Condition 3.

Hennock International Ltd

Section F - note that this is for the first 6 downpipes and is 150mm dia PVC, therefore will be all above ground.

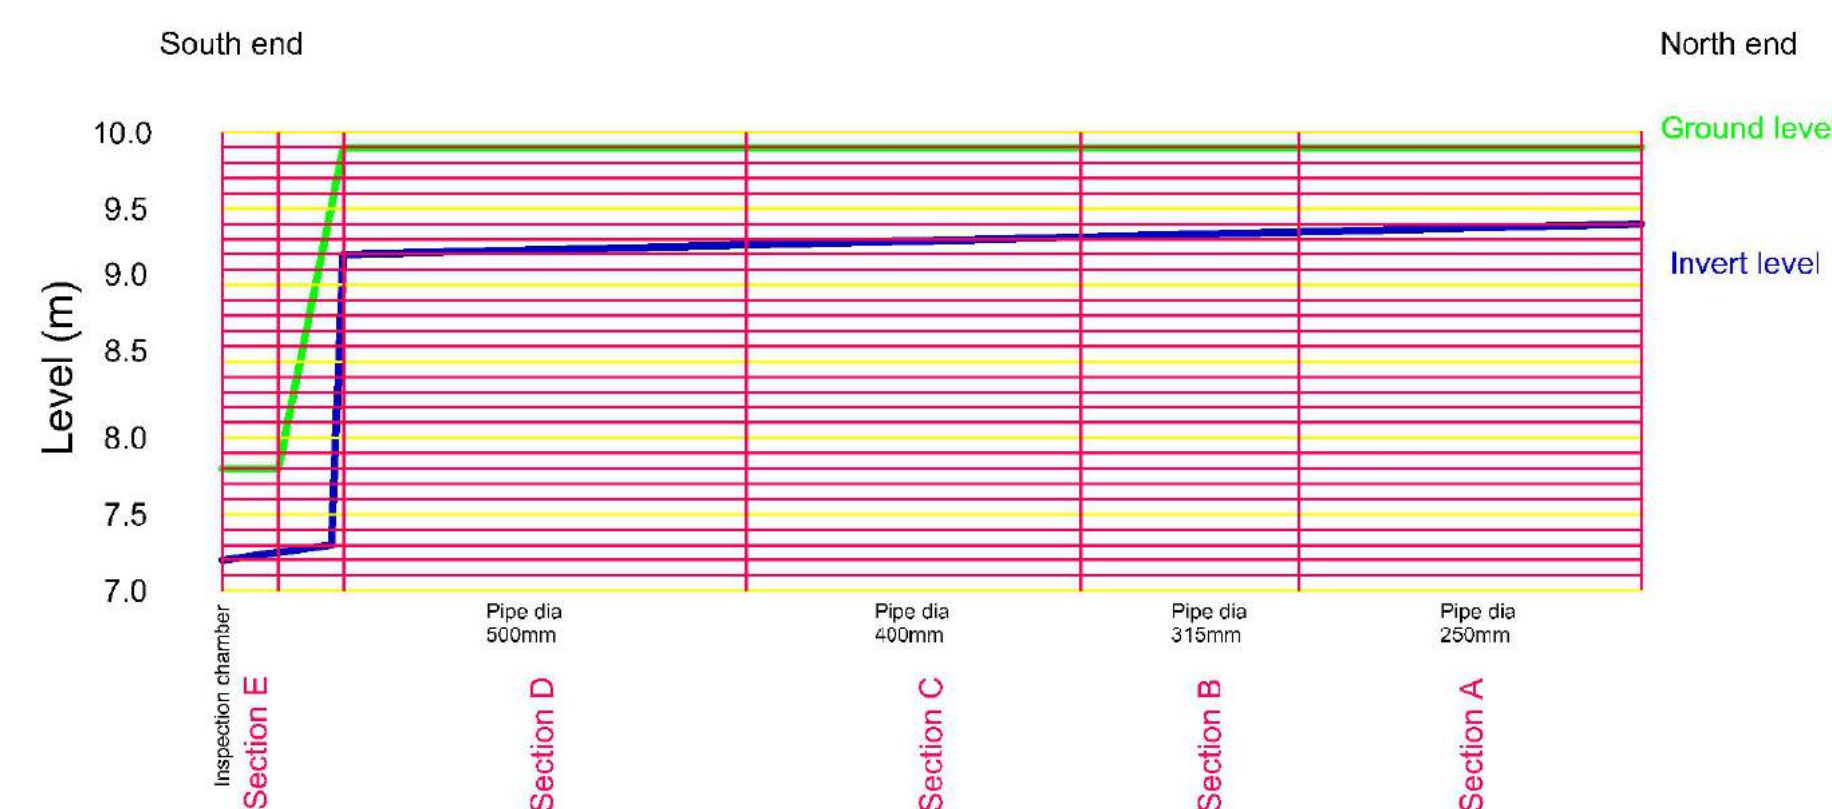
We presume that this relates to drawing "Invert levels", and have added additional items that hopefully render it clearer. If it refers to a different drawing please identify it for us.

This drawing has now been expanded out into 5 drawings for clarity.

Pipe and invert #1 - overall site layout naming the blocks as detailed in #2-5.

Pipe and invert #2 - North greenhouses (which are the only ones to feed the north outfall)

Pipe and invert #3 - South east greenhouses (which feed the south outfall)

Pipe and invert #4 - East greenhouses (which feed the south outfall)

Pipe and invert #5 - South west greenhouses (which feed the south outfall)

Diameter / depths etc. As far as we are aware all this information is submitted, but we have tried to make it clearer and split drawings, add text etc. to assist in this. This is all contained on the "Pipe and invert" drawings.

Drainage
Overall site layout

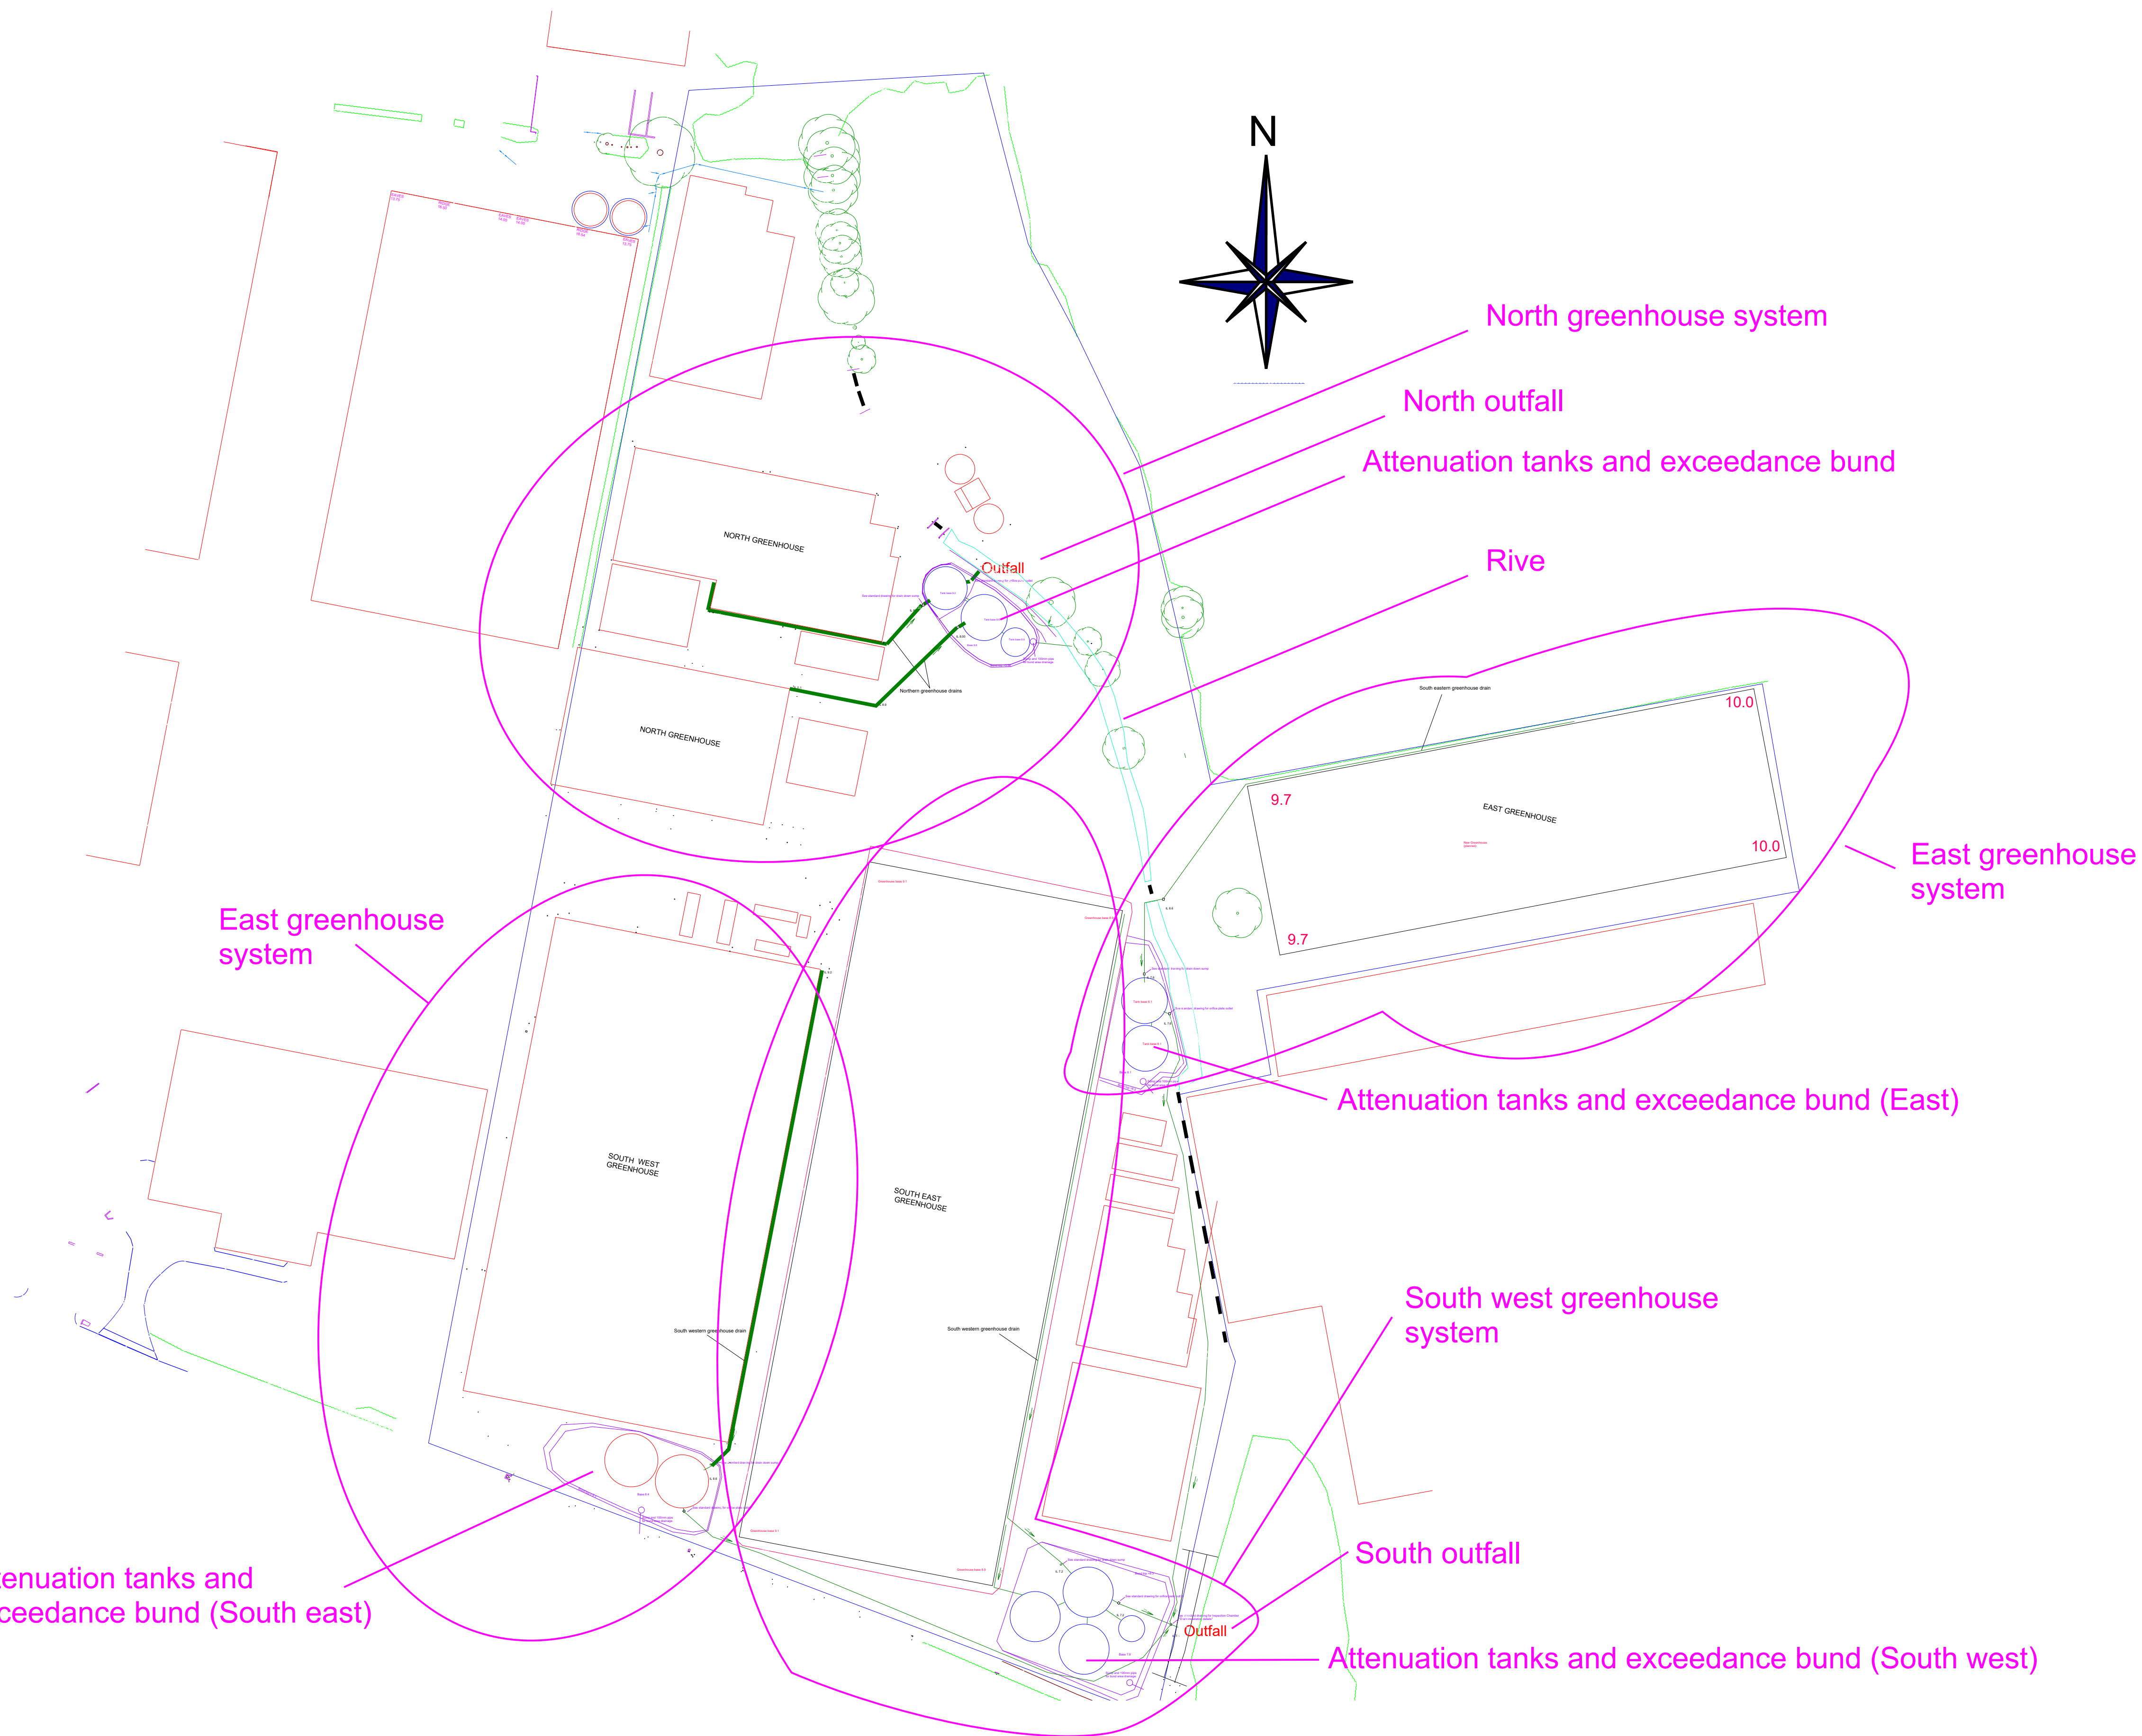
See also "Layout" drawing for introduction.

See also "layout" drawing.

Non SE orifice plate
discharge details
(North, East, SW).

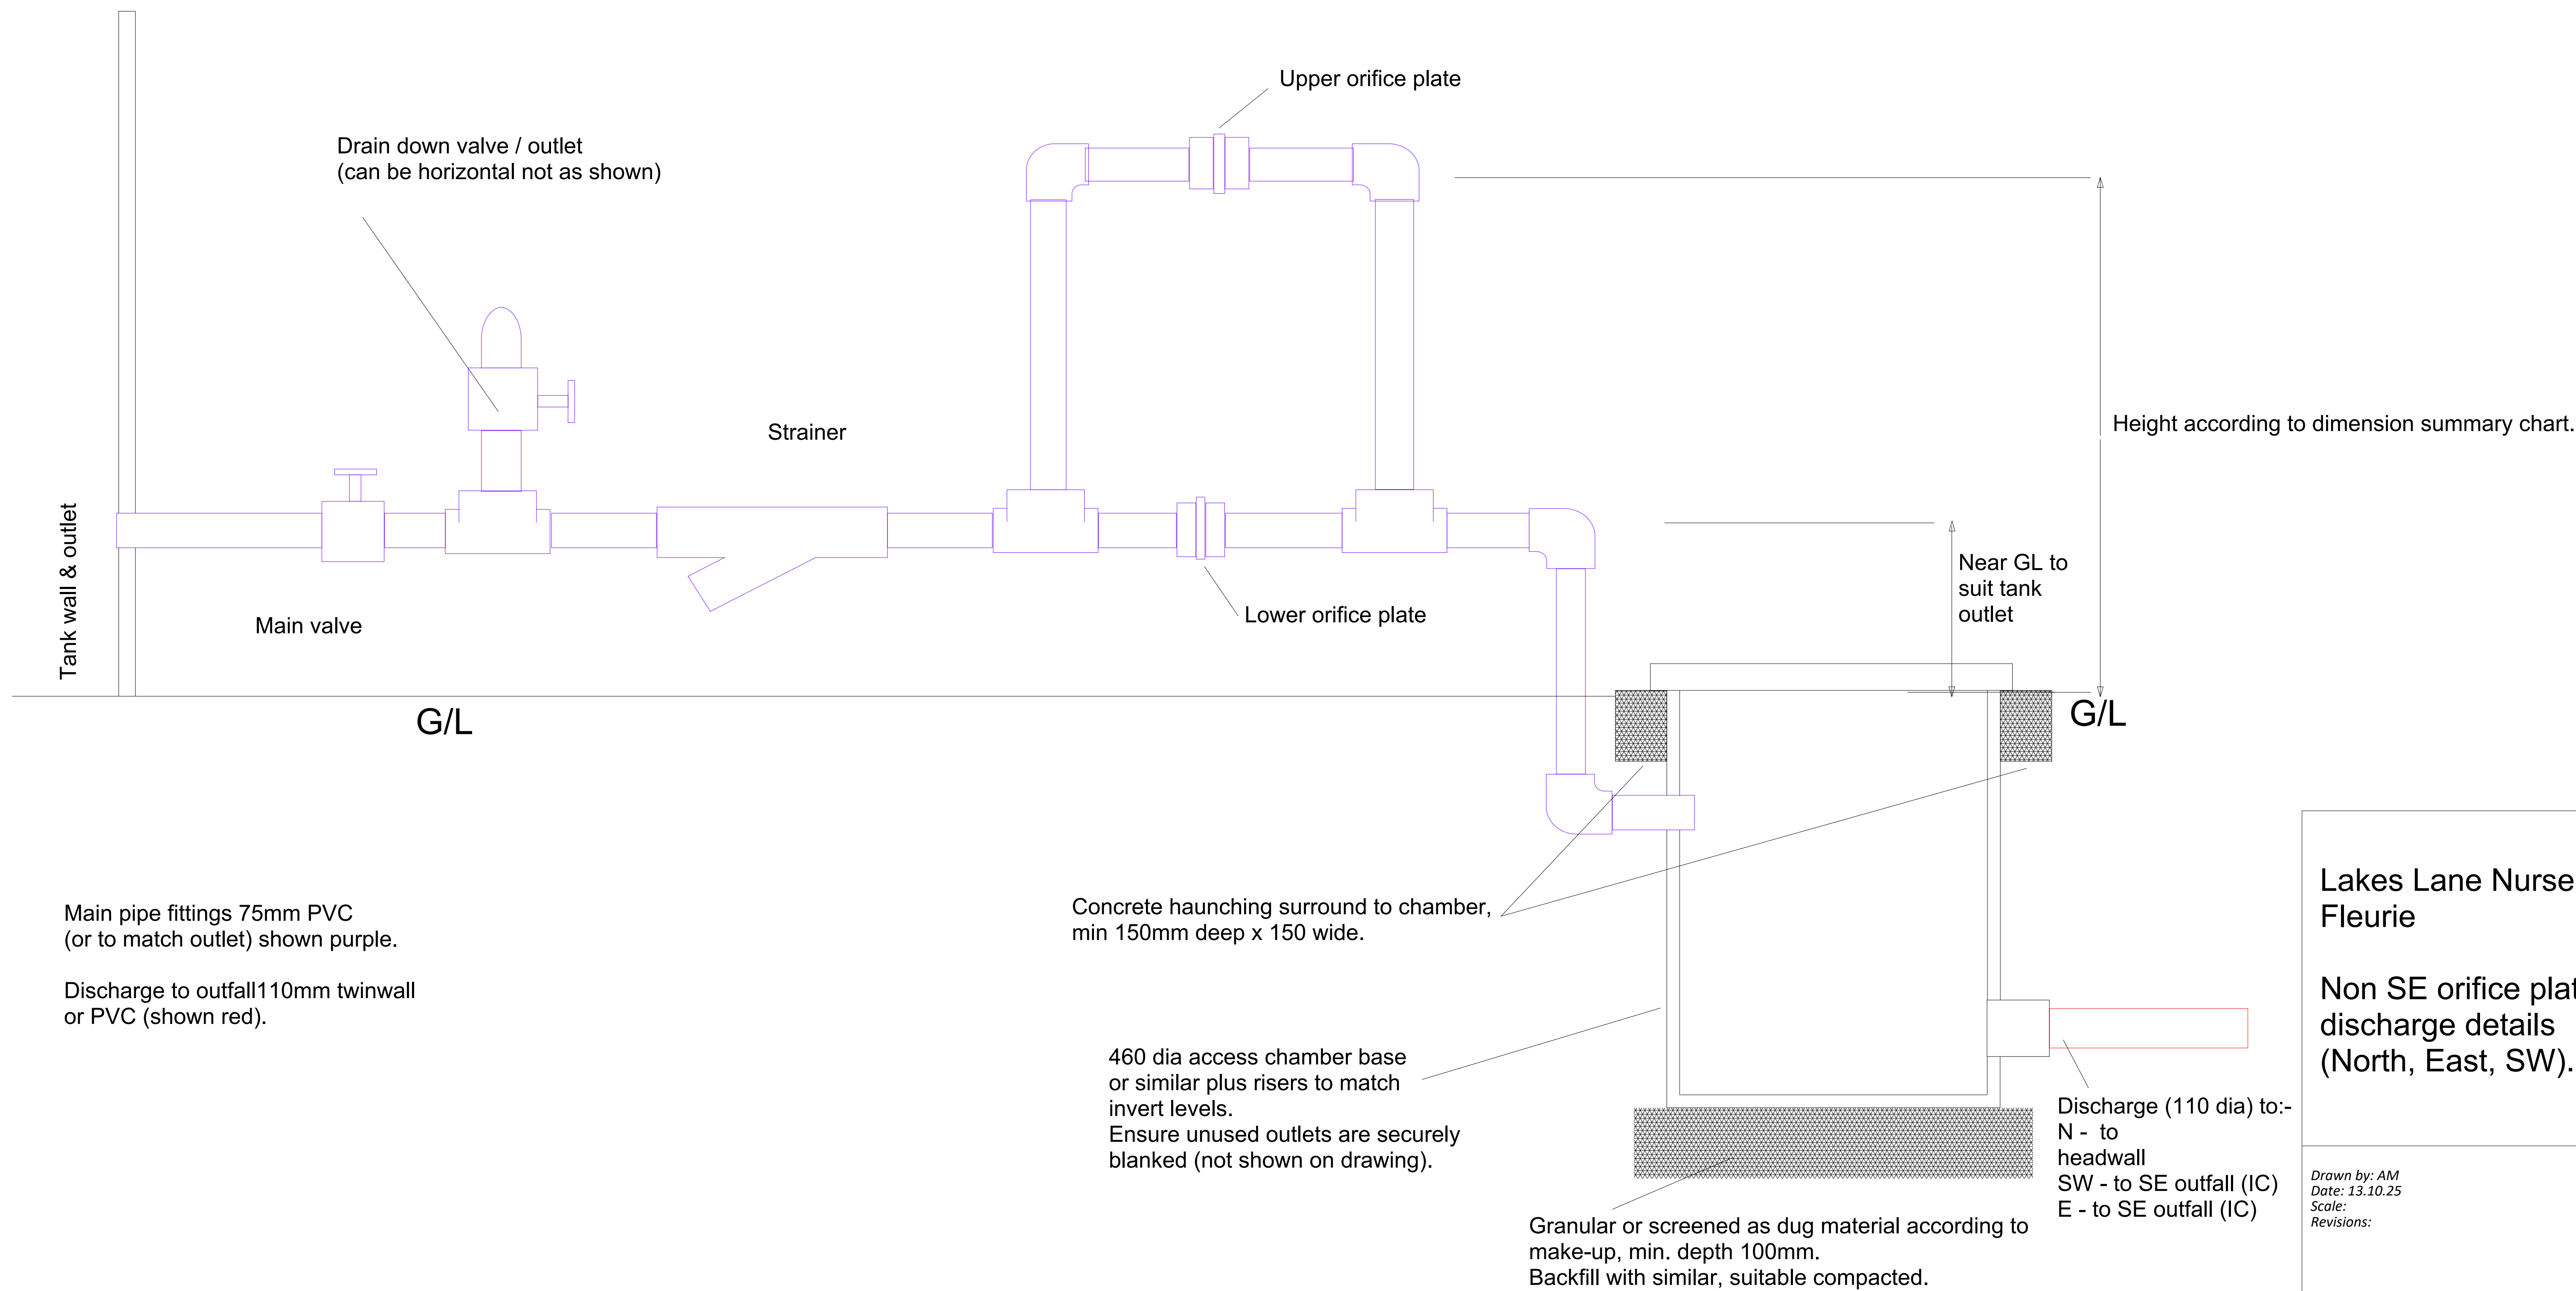
"See attached drawing "Orifice plate outlet detail".

The installation is straightforward, with a tank connector from the attenuation tank connected to a pipe (all pipework 75mm PVC glued or threaded joints) passing through an isolating valve, then a T piece for connection to draindown valve (maintenance) and thence to a strainer (filter) and to the T where the flow will normally exit through the lower orifice plate, but as levels in the tank rise to above the upper orifice plate then through this too. Orifice plates are stainless steel with EPDM gaskets (both sides) and clamped in position by the flanges it is mounted between, with coupling bolts to hold it in situ. The outlet from the plates goes to an inspection pit, with low level exit (110mm dia) to the discharge outfall."
